Your Ref: OWPC5651
Our Ref: R/105/15/PL 22-04-2015
Please ask for:
Mrs A Gardner

New area of interlocking grass-block system to North-East to provide for relocation of minibus parking (partial resubmission following R/307/14/PL).

Princess Marina House 61 Seafield Road Rustington

JOB number:	drawing number:	revision:
2082	(11)001	1
project:	Princess Marina House	
client:	Seaside Apartments	
client:	RAF Benevolent Fund	
title:	Parking Plan	
date:	22/04/15	scale:
	1:100 @ A1	drawn: GT
		checked: CS

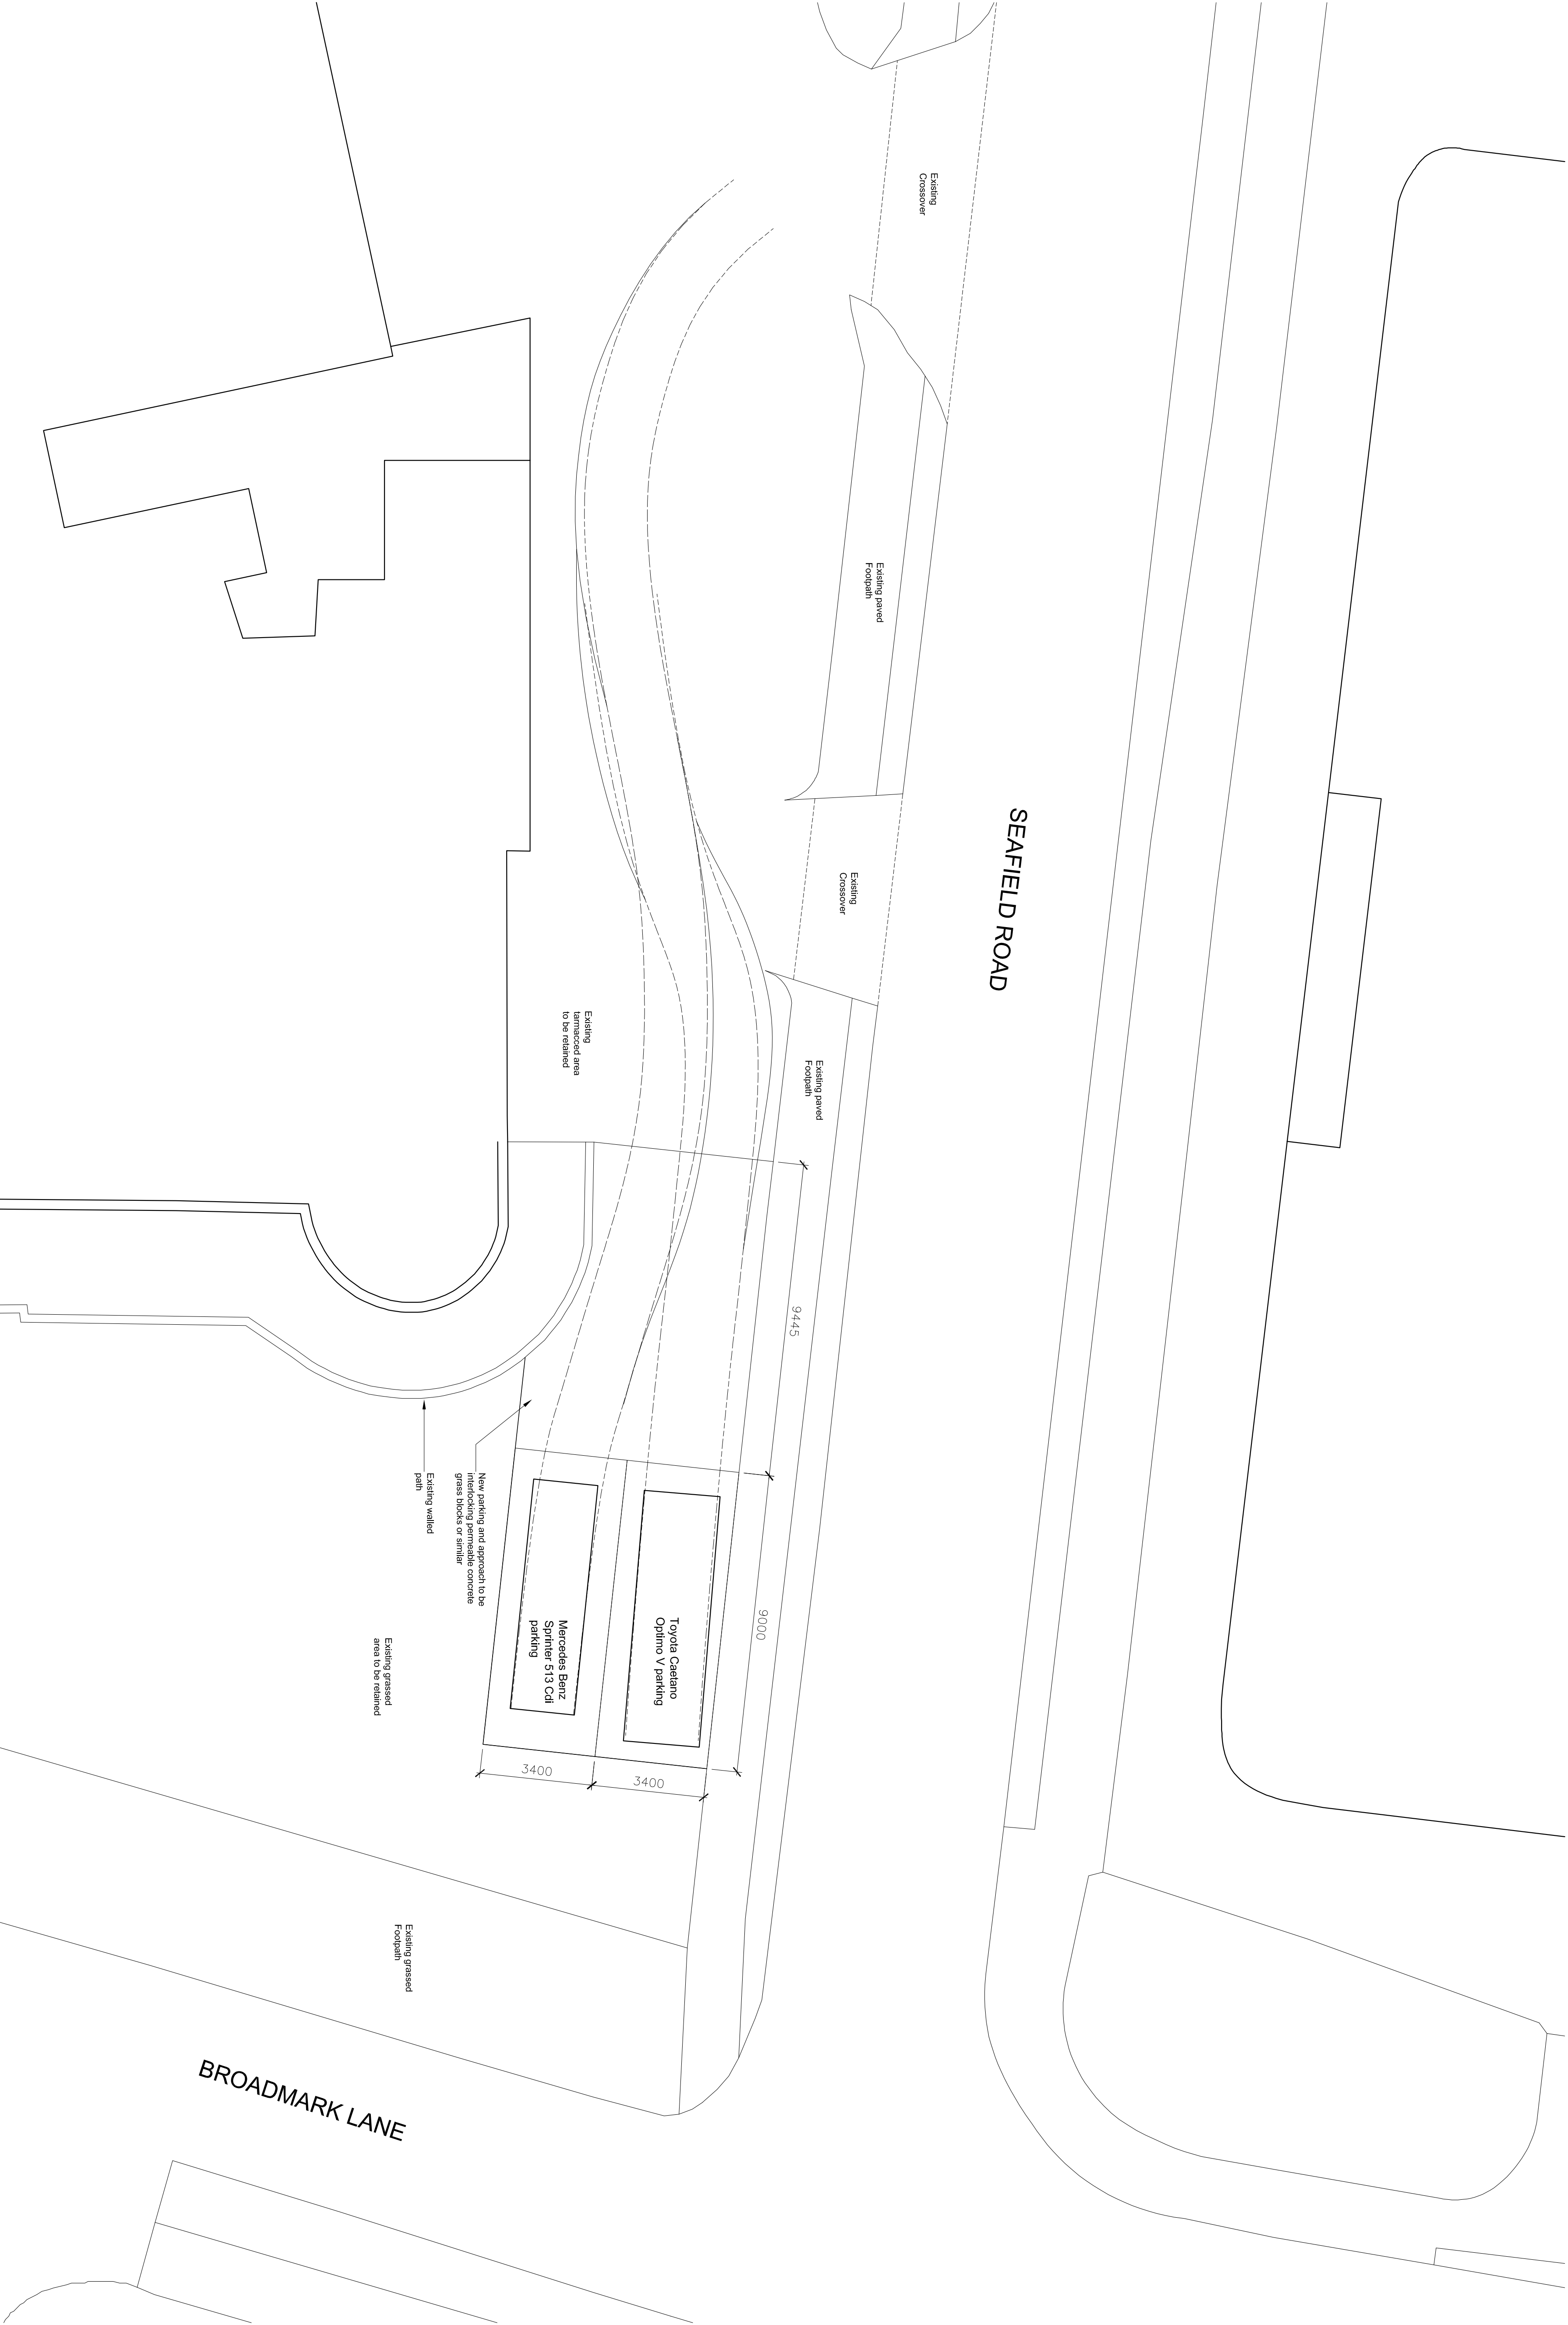
Parking 2 large vehicles in the position shown on the plans would have considerable visual impact for the residents of Heritage Place, Broadmark Beach and the houses on the east side of Broadmark Lane.

Our apartment is on the ground floor of Heritage Place and our view of the beach and sea would be obliterated if the plan goes ahead.

The award-winning gardens at Princess Marina House are very attractive and well -tended and having 2 minibuses parked in the garden would have a detrimental effect on the whole area at the southern end of Broadmark Lane.

With the resources and amount of land available to the RAFFB on their site, we are sure that a compromise can be reached on the positioning of their vehicles.
